**Subject:** Planning Response 20/02060/F- Public Rights of Way OBJECTION

Bourton Footpath 8 runs through the proposed development, although it is shown on none of the documents submitted as part of the planning application.

# SITE LAYOUT PLAN

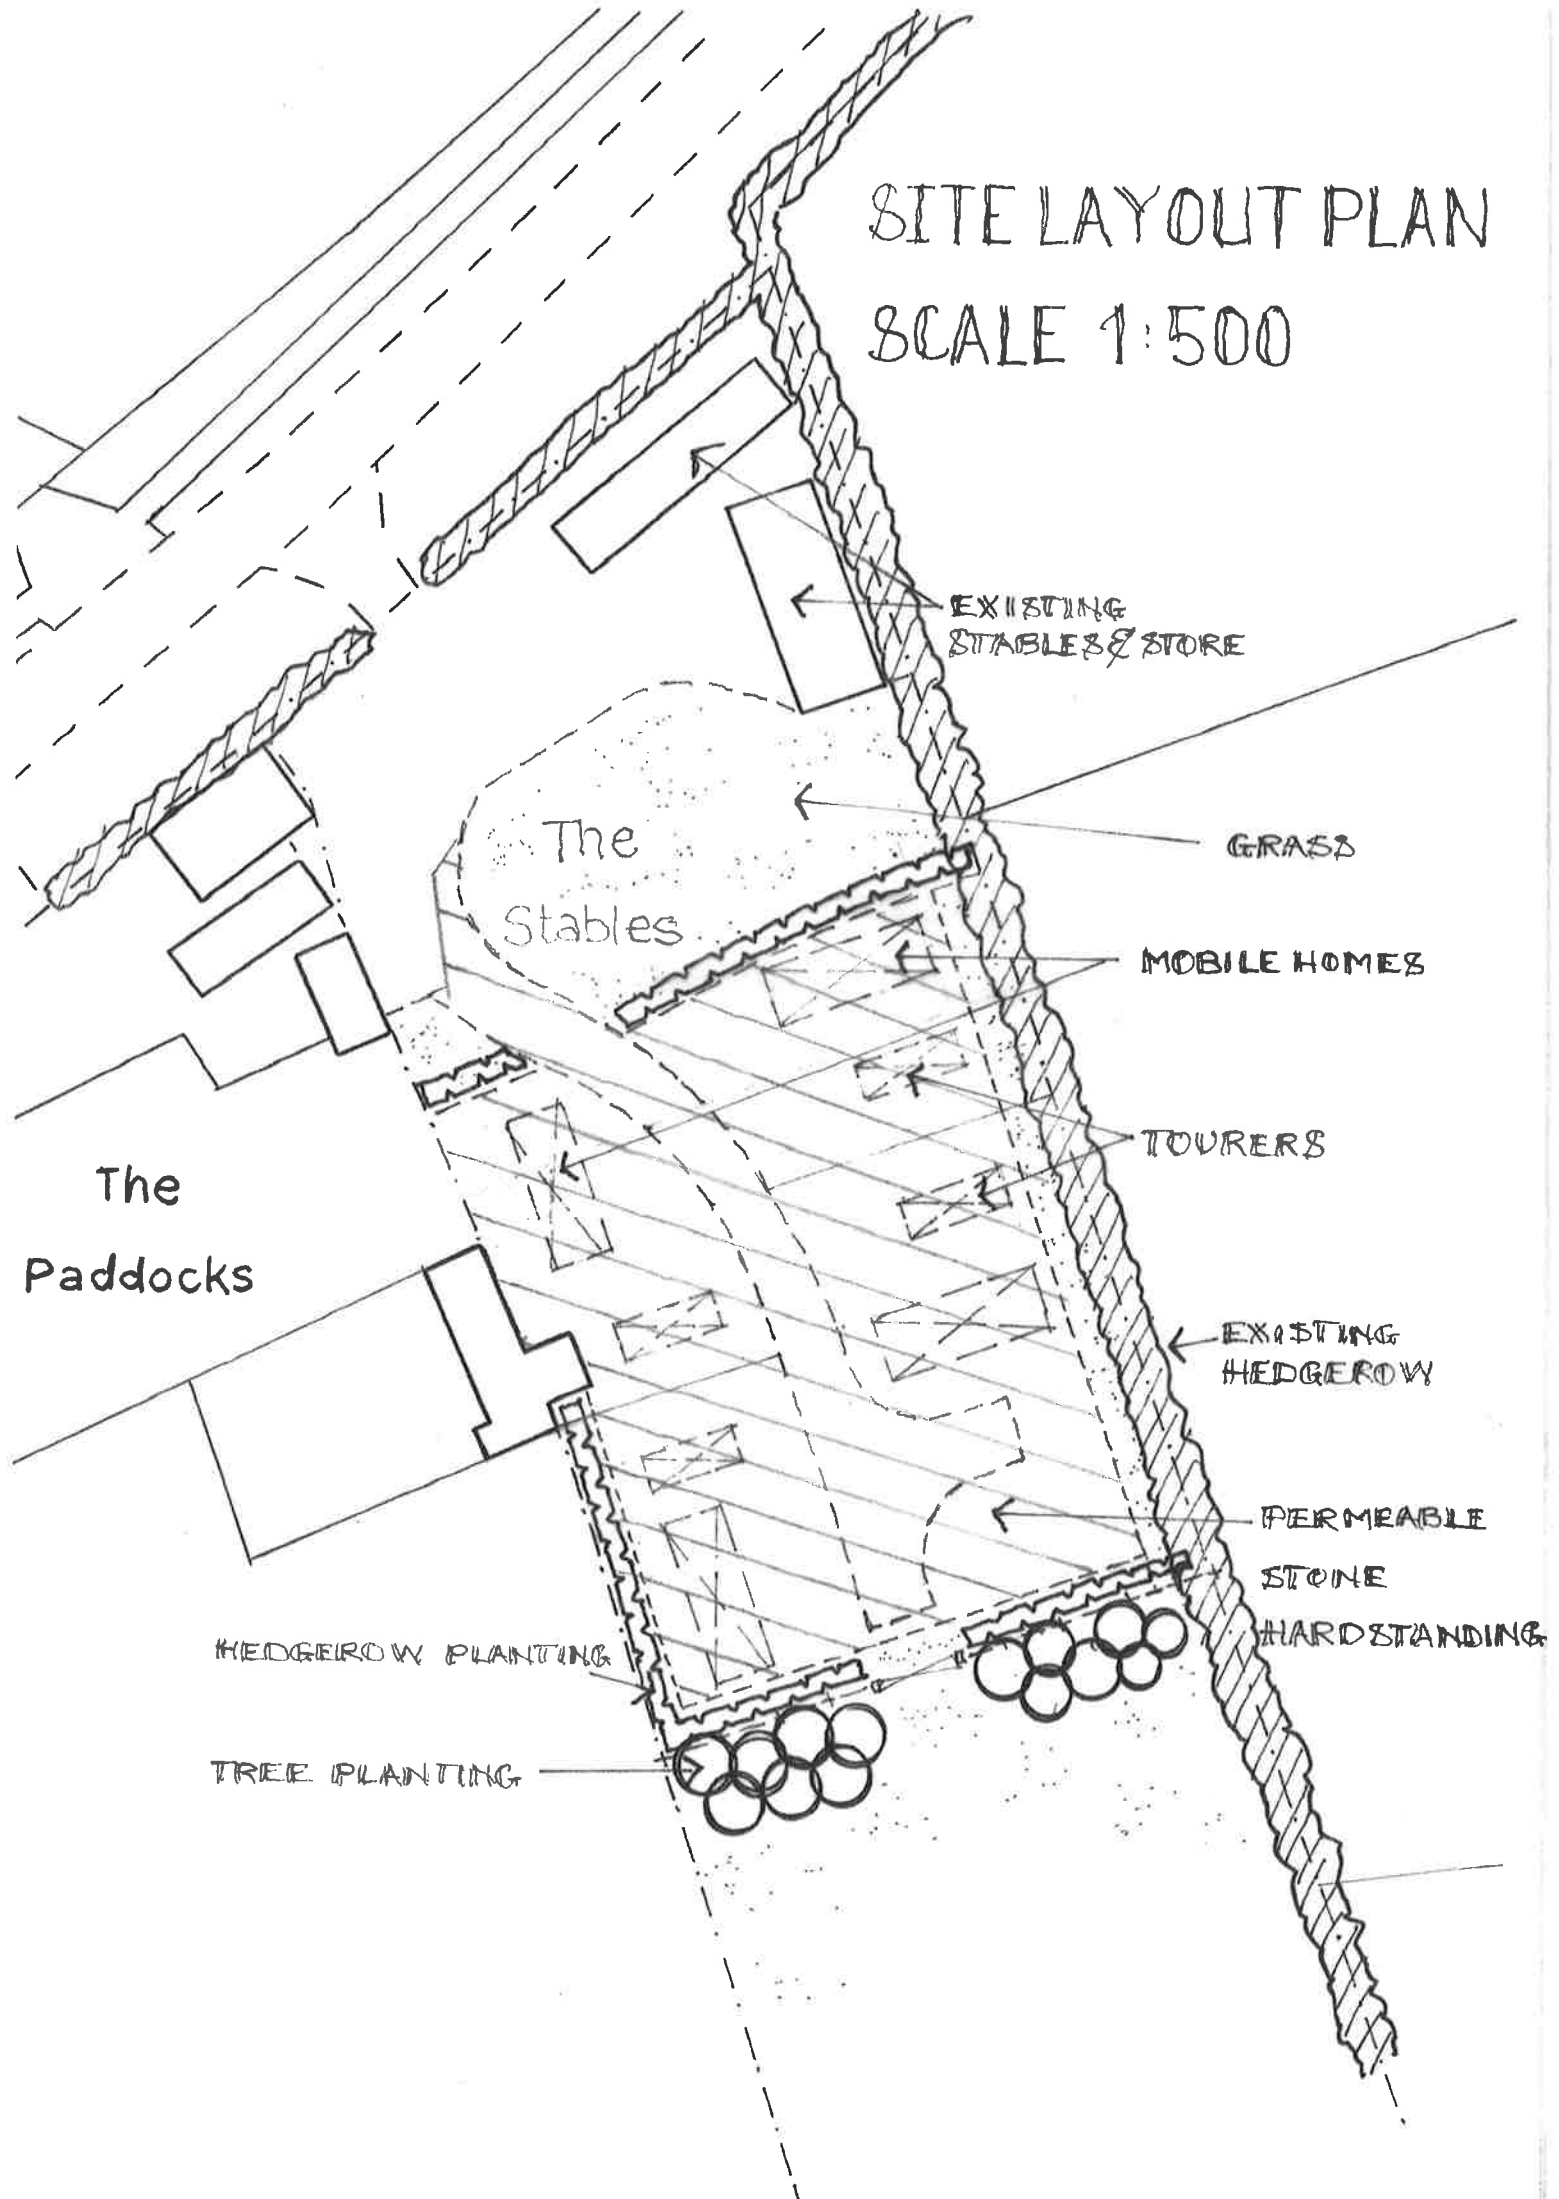
Oxfordshire County Council **OBJECT** to this planning application as the proposed plans would obstruct the Public Right of way. The proposed mobile homes, new hedging and fencing would all obstruct the Public Footpath.
